CITY OF ALBUQUERQUE

August 10, 2022

**Re: Scooter's Coffee Store #1175
2509 San Mateo Blvd NE
Traffic Circulation Layout
Engineer's Stamp 06-30-2022 (H17-D116)**

SHEET  
C1.1

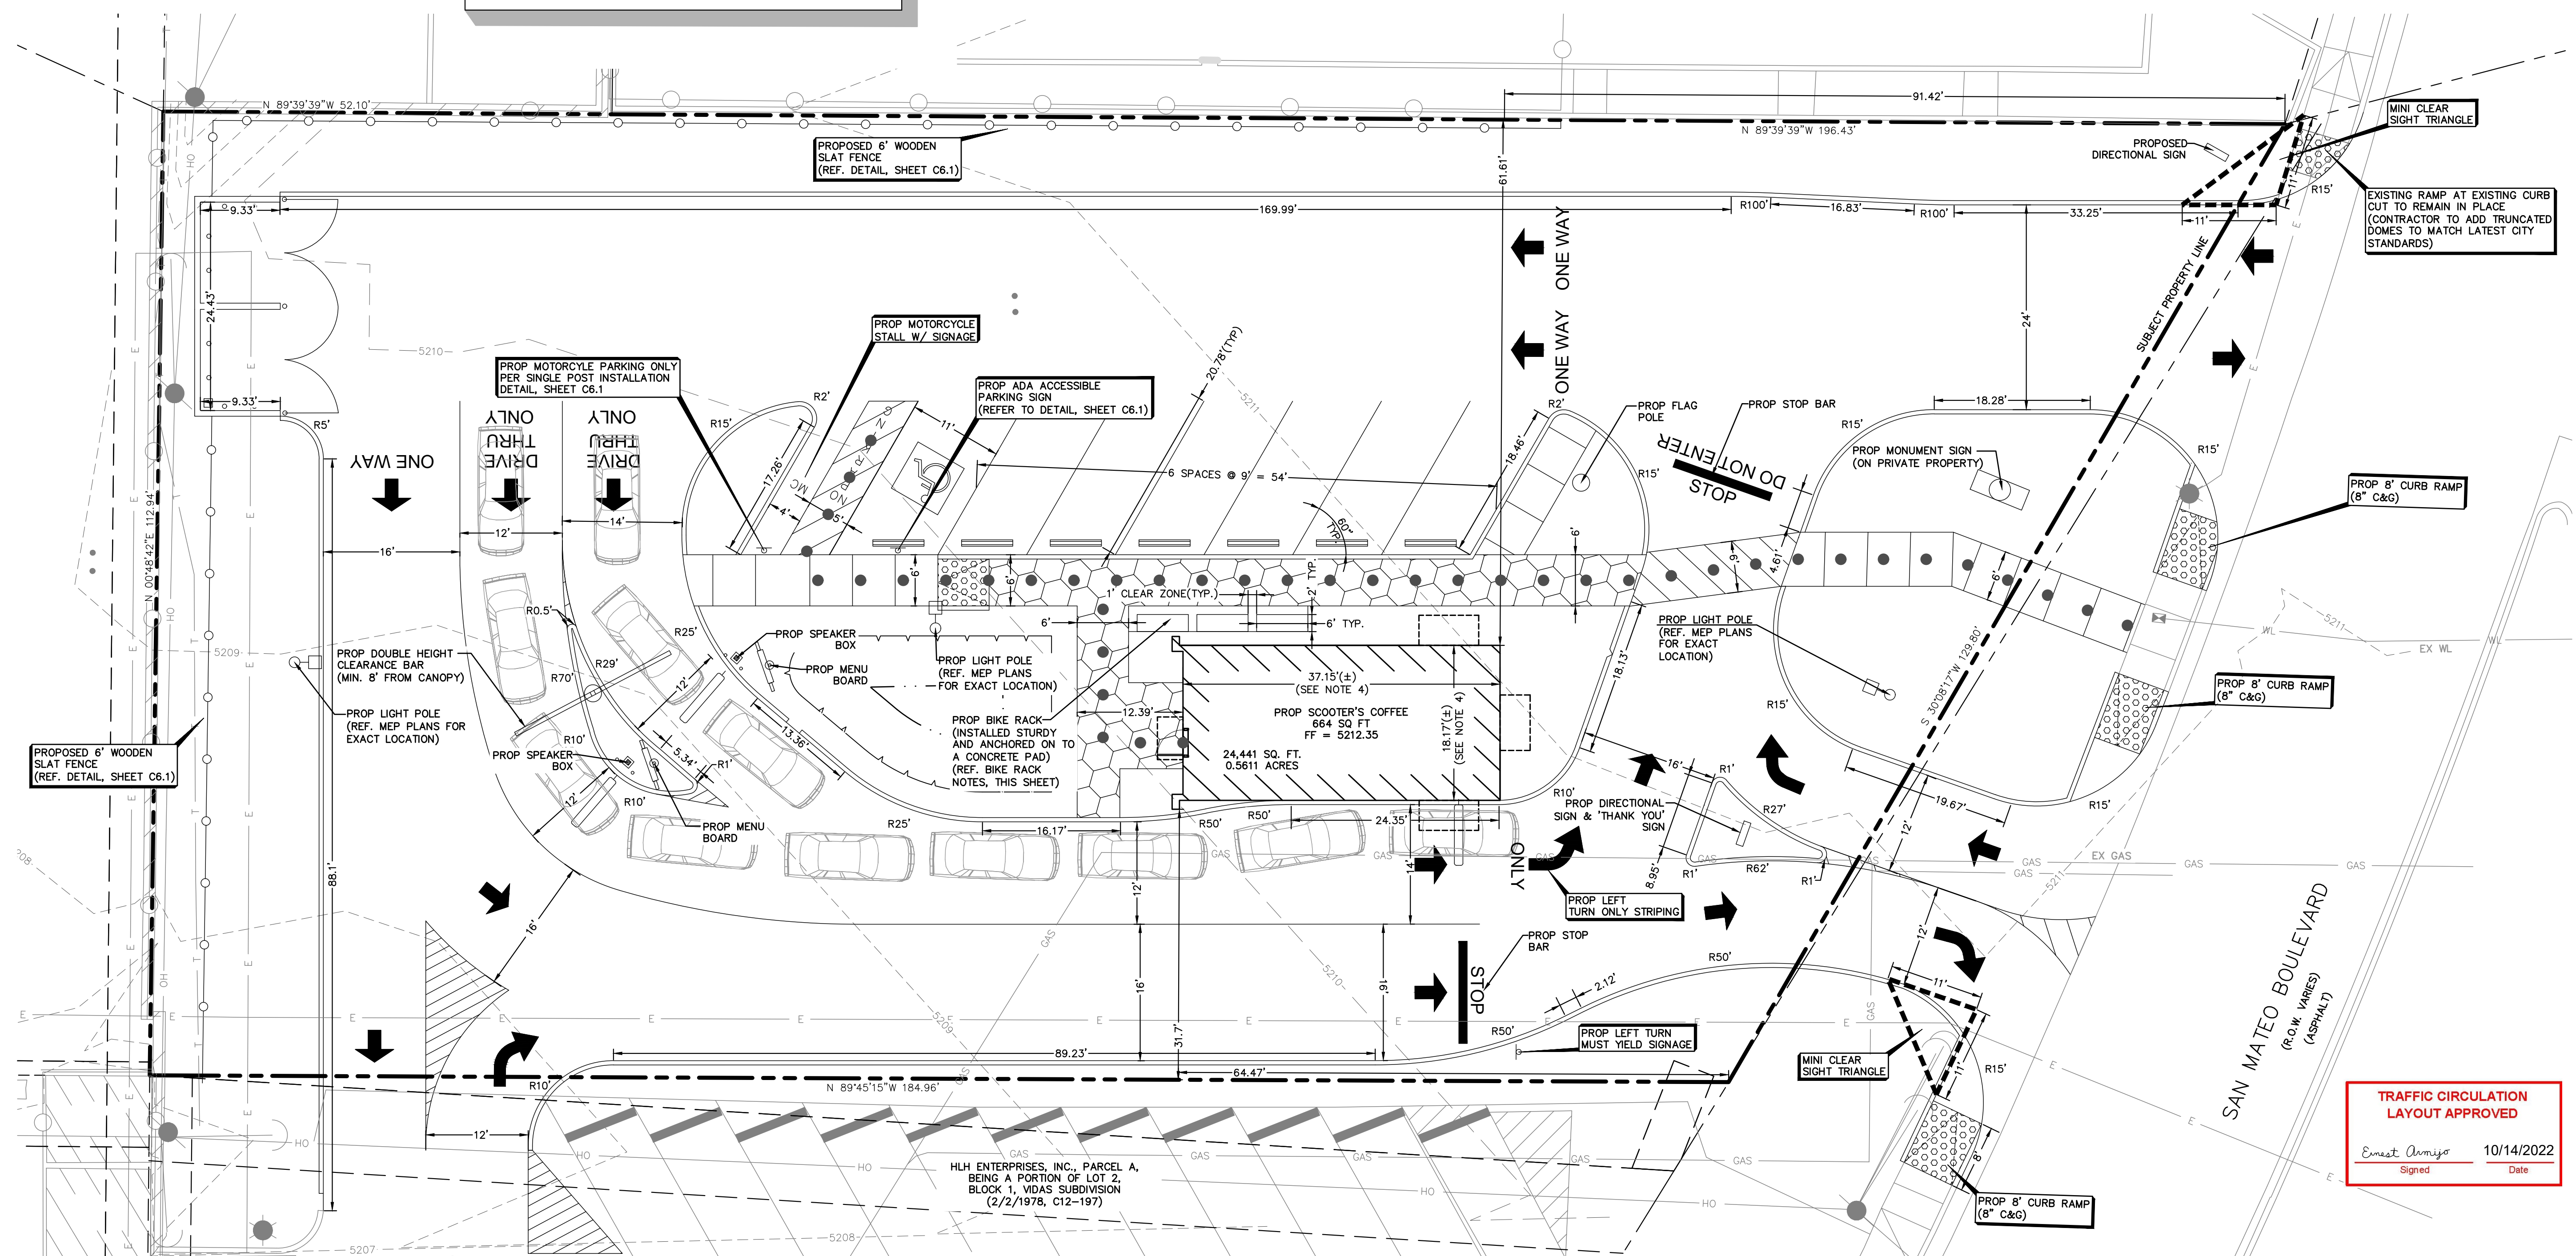
4. A queuing analysis for peaks hours will be needed for this development to ensure that queuing doesn't backup into San Mateo.
5. South access to adjacent property: Will need adjacent landowner permission for pavement markings located within their property.

6. **San Mateo Frontage:**
 - Provide driveway entrance design/detail.
 - Proposed striping on the second driveway is inconstant with traffic flow. Please address.

- The proposed radiuses are too narrow/tight for the Arterial roadway turning movement. Please review DPM to determine an appropriate turning radiuses for vehicles.

- Proposed ramp is in conflict with sidewalk connection into site. Remember ALBUQUERQUE has 8 inch c&g and this will need to be incorporate into the ramp run length and the landing length.

8. The ADA access aisles shall have the words **"NO PARKING"** in capital letters, each of which shall be at least one foot high and at least two inches wide, placed at the rear of the parking space so as to be close to where an adjacent vehicle's rear tire would be placed. (66-1-4.1.B NMSA 1978). **Provide detail.**

15. List radii for all curves shown; for passenger vehicles. Radius for delivery trucks, fire trucks, etc. is 25 ft. or larger. **Internal radii's should be 15'R minimum.**

22. All one-way drives shall have "One Way" and "Do Not Enter" signage and pavement markings. Please show detail and location of posted signs and striping.

23. The minimum drive through lane width is 12 feet with a 25 foot minimum radius (inside edge) for all turns. (A 15 foot radius can be used with an increase in lane width to 14 feet). Please dimension all lane widths and radii.

24. Please provide a sight distance exhibit
25. Show the clear sight triangle and add the following note to the plan: "Landscaping and signage will not interfere with clear sight requirements. Therefore, signs, walls, trees, and shrubbery between 3 and 8 feet tall (as measured from the gutter pan) will not be acceptable in the clear sight triangle.
